From: Hampel Philip
Sent: 08 January 2021 11:30
To: Savage Brian
Cc: Beardsworth Robert; Development Control
Subject: Marina Mews - 21/00009/CONDET
Attachments: 875305.docx; 892674.pdf

Application Number: 21/00009/CONDET
Proposal: Discharge of conditions for 20/00661/FULL - Installation of 3x balconies - condition 3
At: Marina Mews
Humber Place
Kingston Upon Hull
HU1 1UD

“Condition 3) A detailed drawing of the proposed French doors shall be submitted to and approved in writing by the Local Planning Authority before installation. The doors shall then be installed in accordance with the approved detail (in the interests of visual amenity and to comply with Policy 16 of the Local Plan).”

FRONT ELEVATION

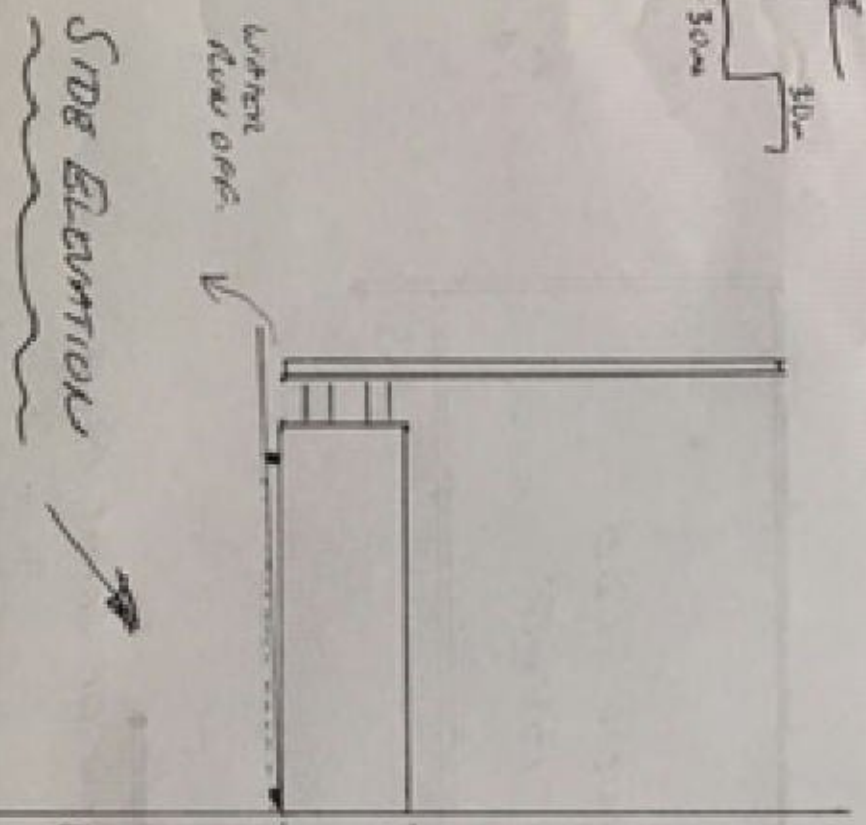
Comments – Having cross referenced the drawing with the manufacturer’s details, I have no objections on conservation grounds, providing the French doors and overlights are set back within the reveals. The doors proposed are of an acceptable appearance and material, being of an aluminium slimline design (which should relate well to the new balconies with glass balustrades).
